Subject: Boweries Barnham Road Eastergate PO20 3RT - BN/135/20/PL

Planning Application Reference: BN/135/20/PL

Proposal: Construction of 30 no. dwellings, new access, public open space, landscaping and associated works (submission following EG/22/19/OUT). This site is a Strategic Site in SP2 (Zero Rated).

Housetype AB

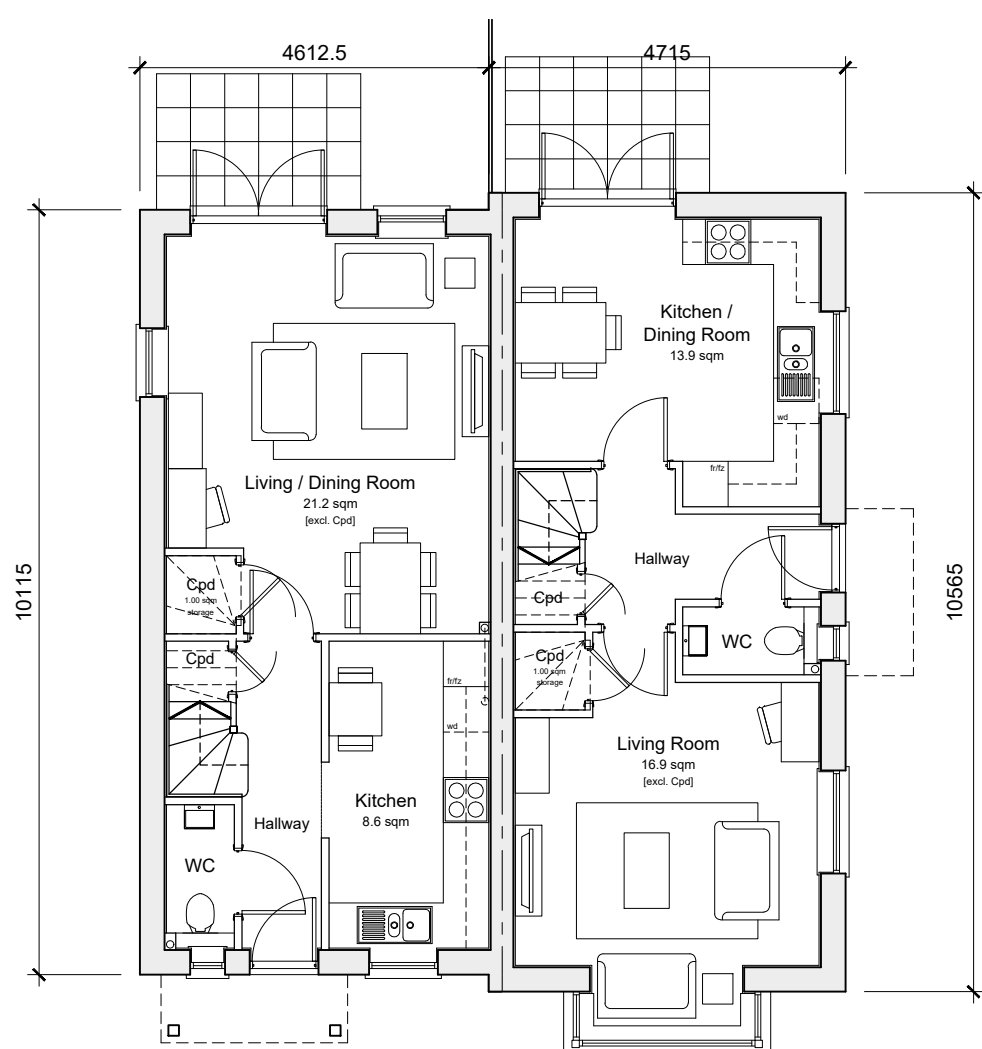
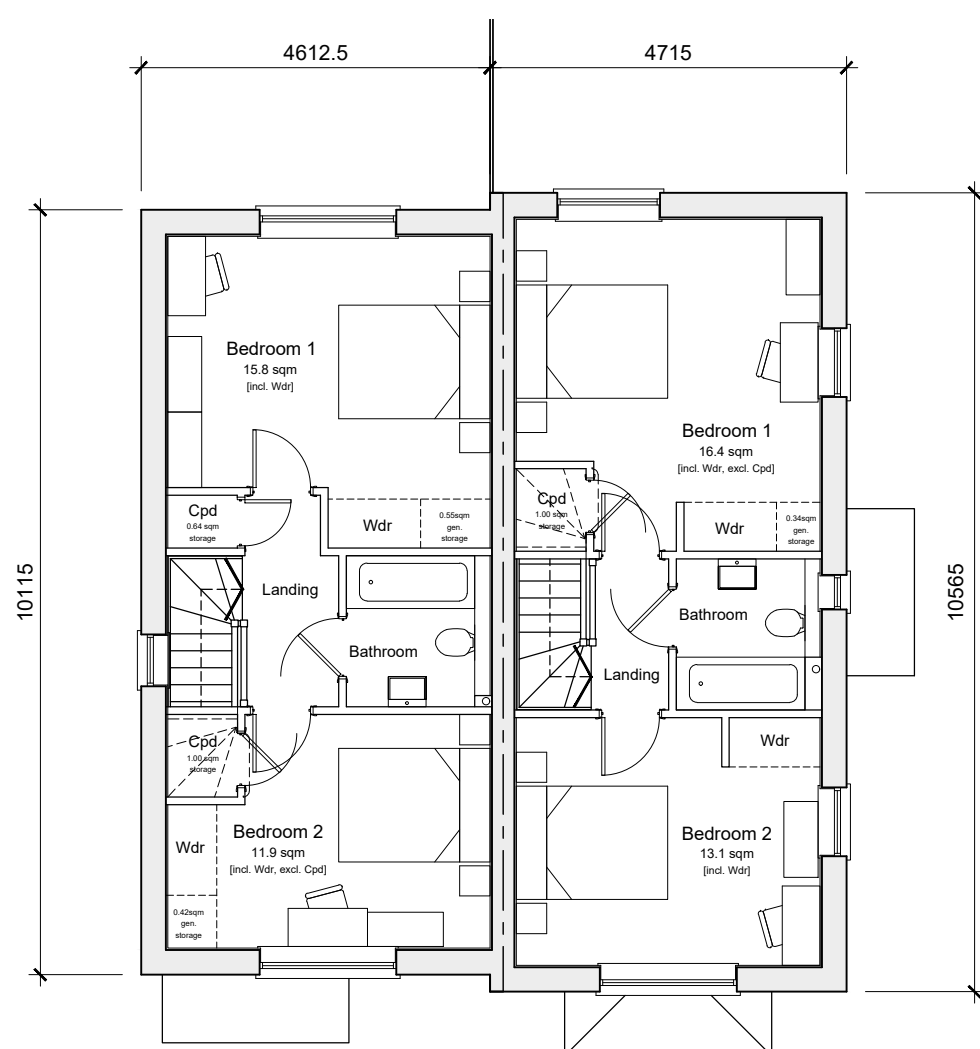
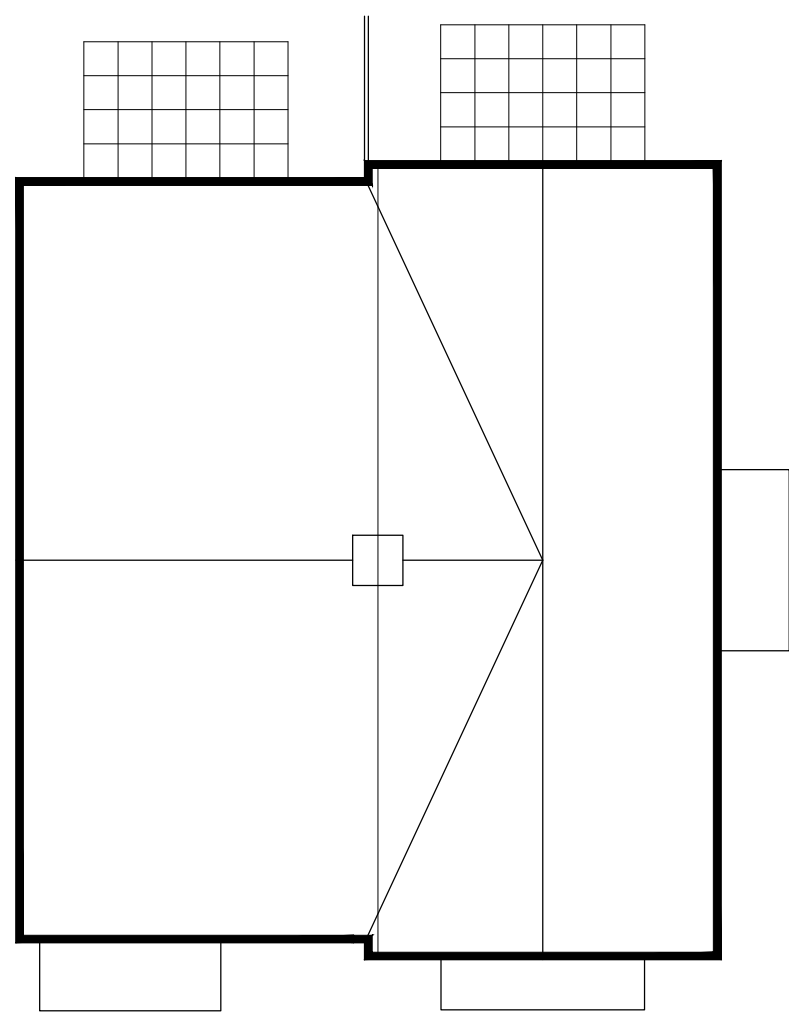
The proposed 'house type AC floor plans' show that House Type C1 bedroom 2 is vertically adjacent to kitchen/living room and on the first floor House Type A bedroom 1 is horizontally adjacent to House Type C1 Kitchen/Living/Dining room. This is not an ideal layout and could introduce detrimental noise impacts on resident's use of bedrooms.

The sound insulation of the floor / ceiling between Bedroom 2 on the ground floor and the Kitchen/Living/Dining room on the first floor in house type C1 shall achieve a minimum airborne sound insulation value of 50 dB ($D_{nT,w} + C_{tr}$). Before the residential unit is occupied, a test shall be undertaken by a competent acoustician and submitted to the Local Planning Authority to demonstrate compliance with this level.

The sound insulation of the party walls between Bedroom 1 on the first floor of house type A and the Kitchen/Living/Dining room on the first floor in house type C1 shall achieve a minimum airborne sound insulation value of 48 dB ($D_{nT,w} + C_{tr}$). Before the residential unit is occupied, a test shall be undertaken by a competent acoustician and submitted to the Local Planning Authority to demonstrate compliance with this level.

Kitchen units and worktops in the Kitchen/Living/Dining room in house type 'C1' shall be mounted in a way that shall minimise the transmission of structure borne sound.
